Application by Rosefield Energyfarm Limited for an order granting development consent for the Rosefield Solar Farm

The Examining Authority's (ExA) schedule of proposed changes to the applicant's draft Development Consent Order (dDCO) (Revision 07) [REP4-006]

Issued on: 15 July 2026

SCALE BAR:

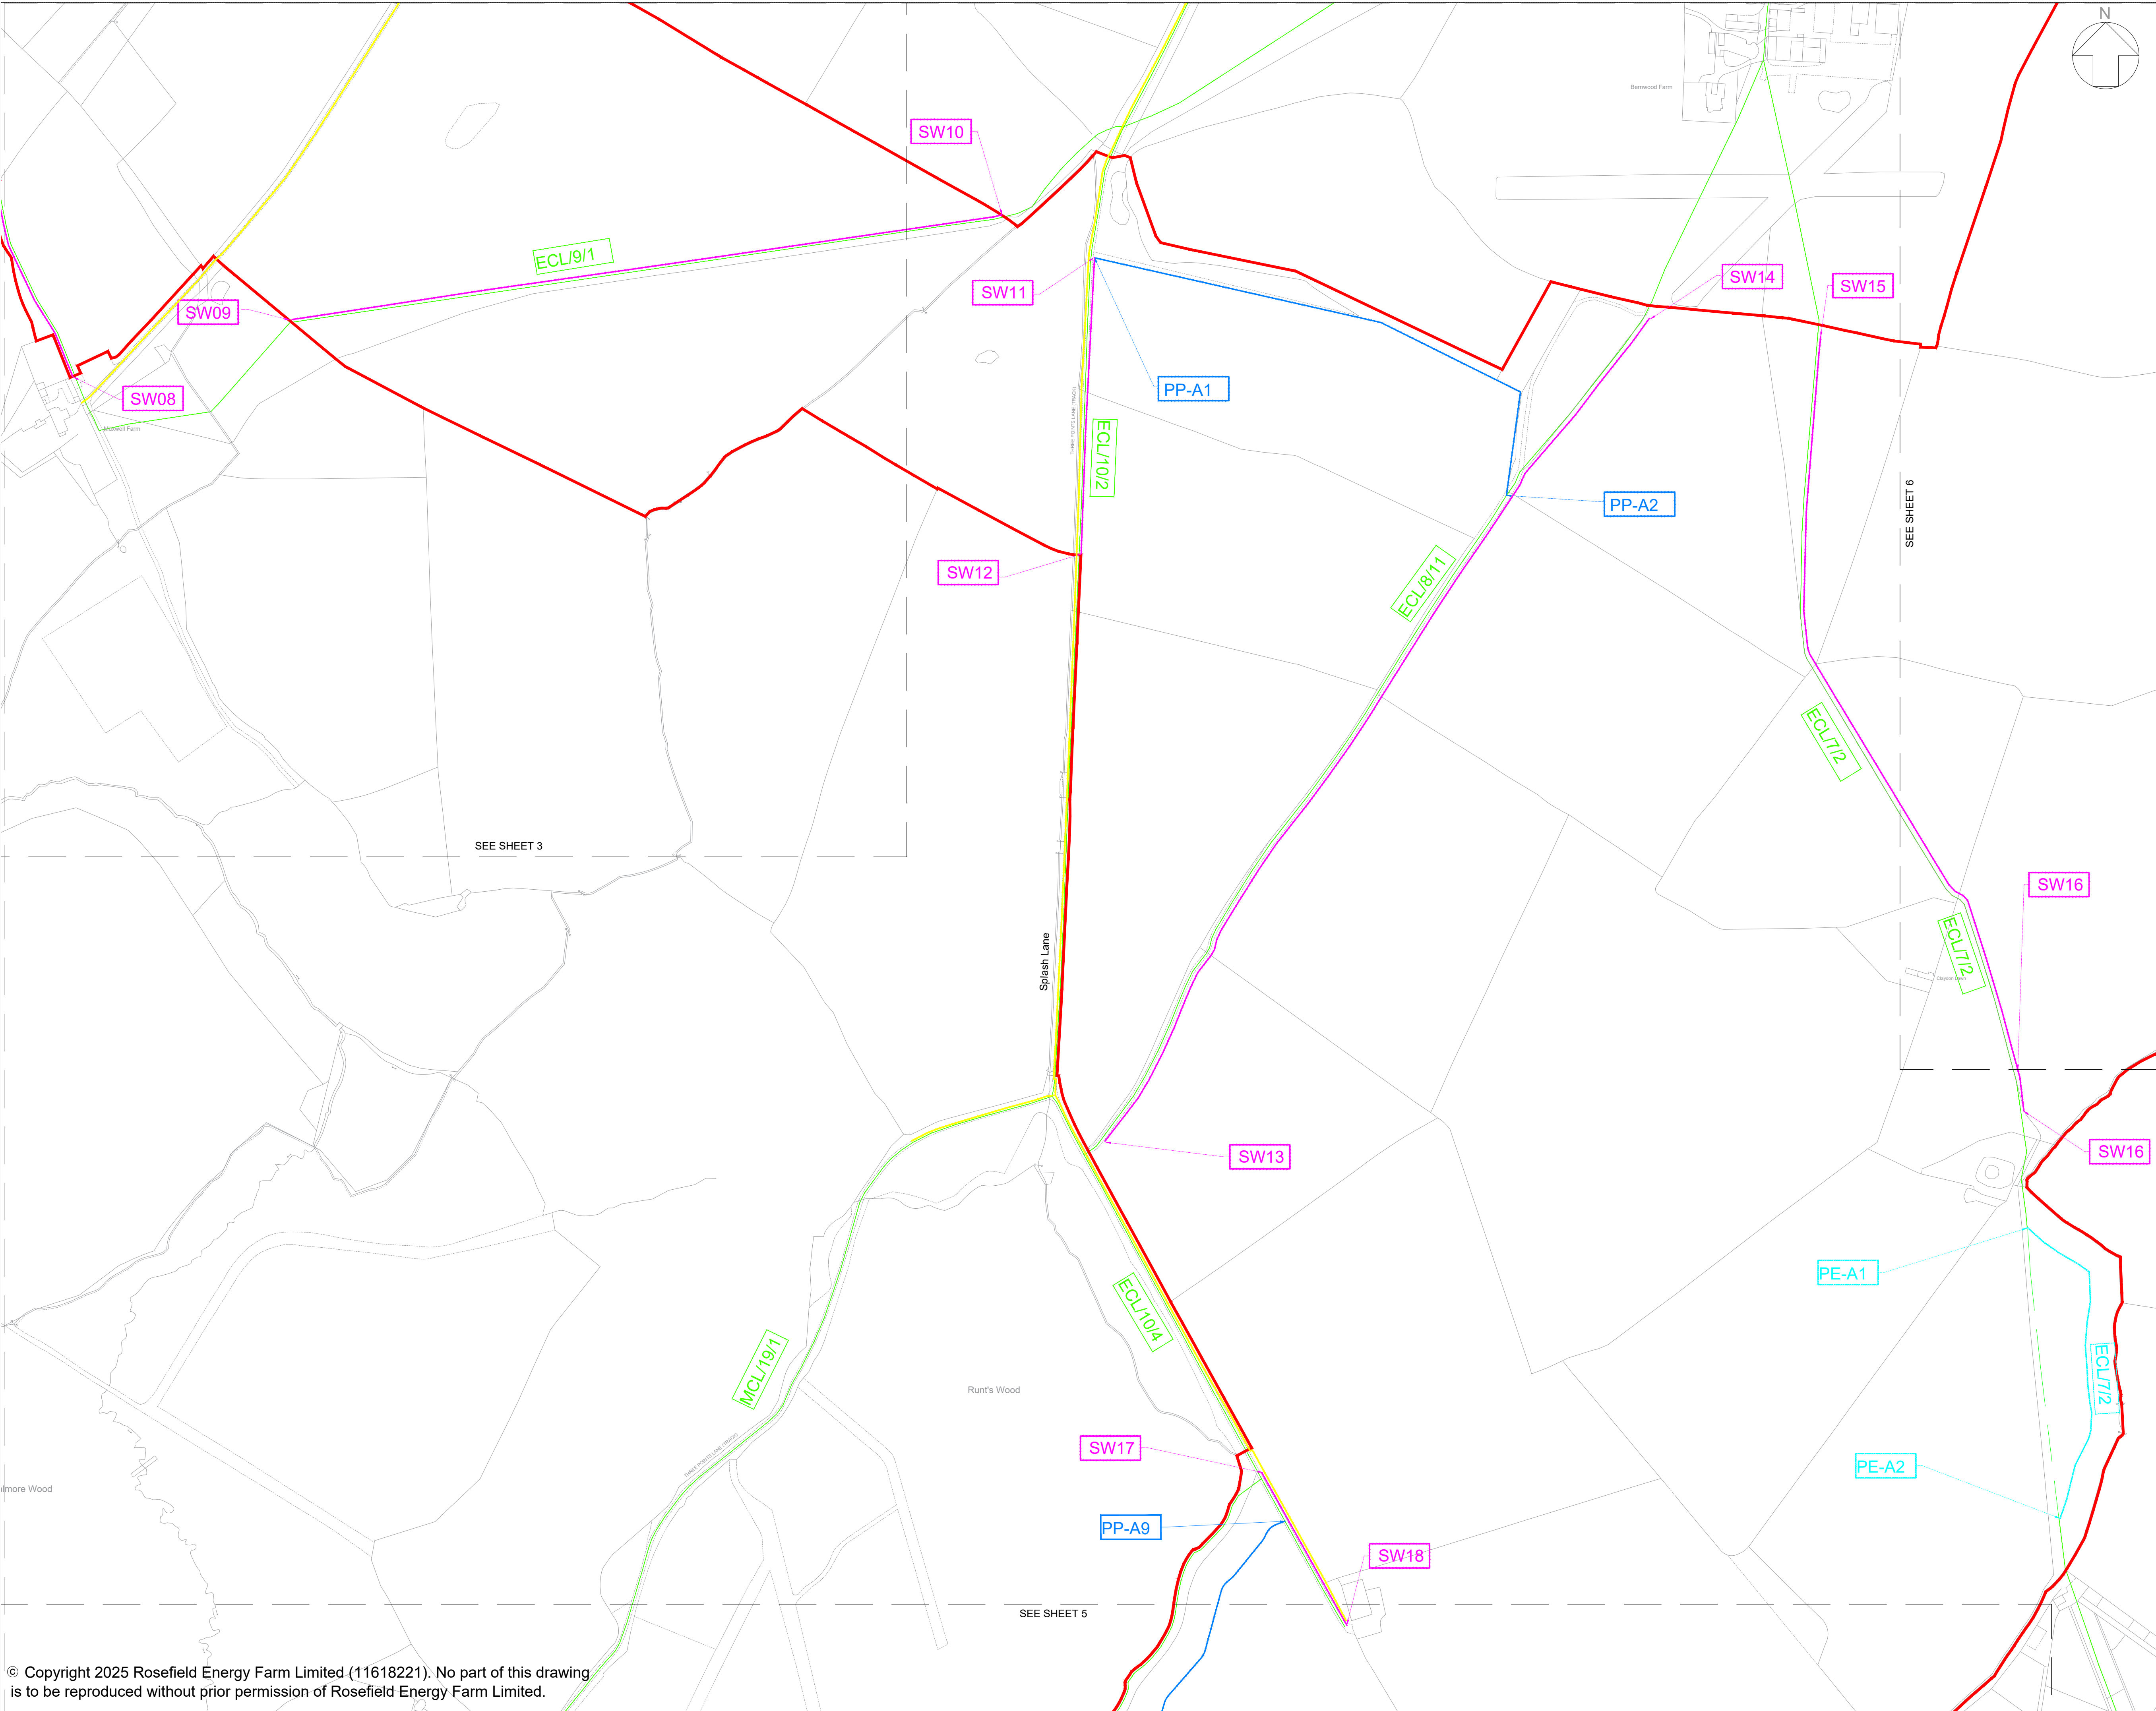
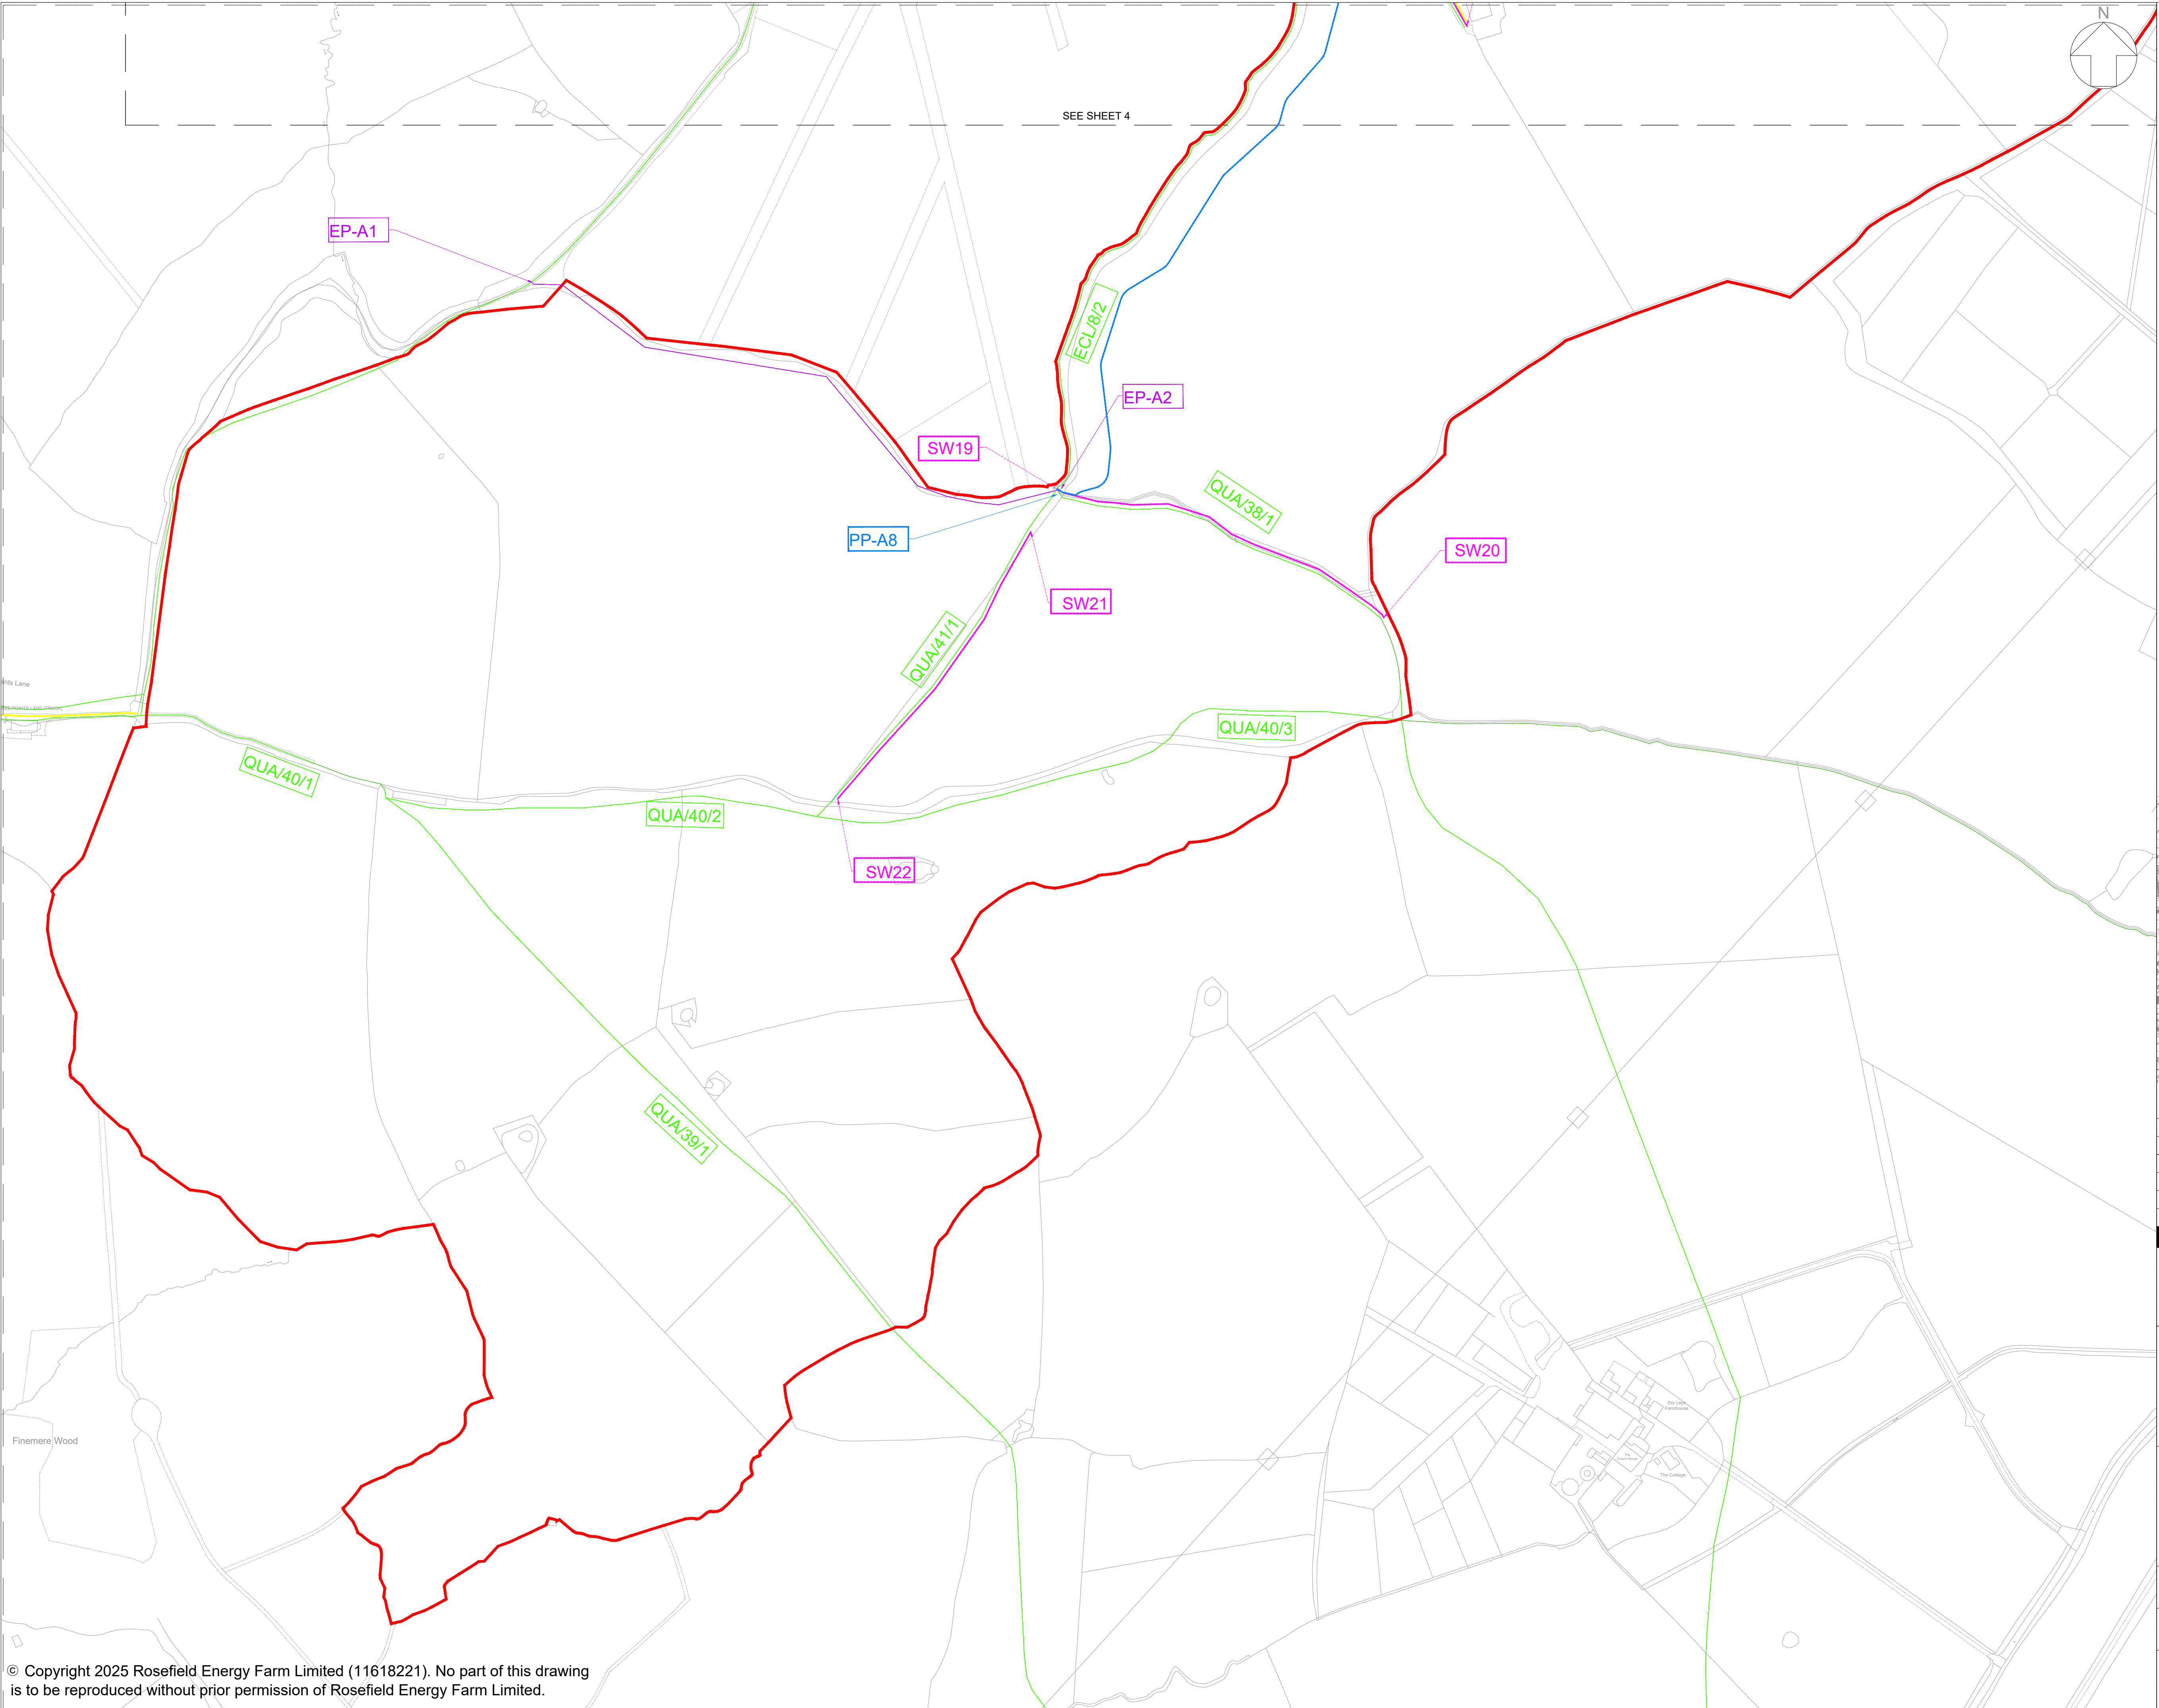
Article/ Schedule	ExA's proposed changes Deletions shown as strike through (for example) Insertions shown in bold (for example)	ExA's reasoning and comments
		However, the ExA considers this should be expressly stated in the dDCO.
Article 12 – Temporary prohibition or restriction on the use of streets and public rights of way	(10) The undertaker must restore any public right of way that has been temporarily altered under this Order to the reasonable satisfaction of the street authority	This provision would be the equivalent to the obligation contained at Article 10(2) and the ExA considers it is required to ensure a proper reinstatement of public rights of way.
Article 14 – Use of private roads	(1) The undertaker may use any the private roads specified in (2) For the purposes of section 9 (requirement of licence for felling) of the Forestry Act 1967(b) any felling comprised in the carrying out of any work or operation required for the purposes of, or in connection with, the construction of the authorised development is deemed to be immediately required for the purpose of carrying out Schedule “X” within the Order limits for the passage of persons or vehicles (with or without materials, plant and machinery) for the purposes of, or in connection with, the construction or maintenance of the authorised development.	The ExA considers that this proposed power is too broad and for clarity needs to be restricted to those private streets that the applicant intends to use for the proposed development. The update to the Streets, Rights of Way and Access Plans at deadline 4 [REP4-005] does not provide this clarity, only showing the location of all private streets within the order limits.
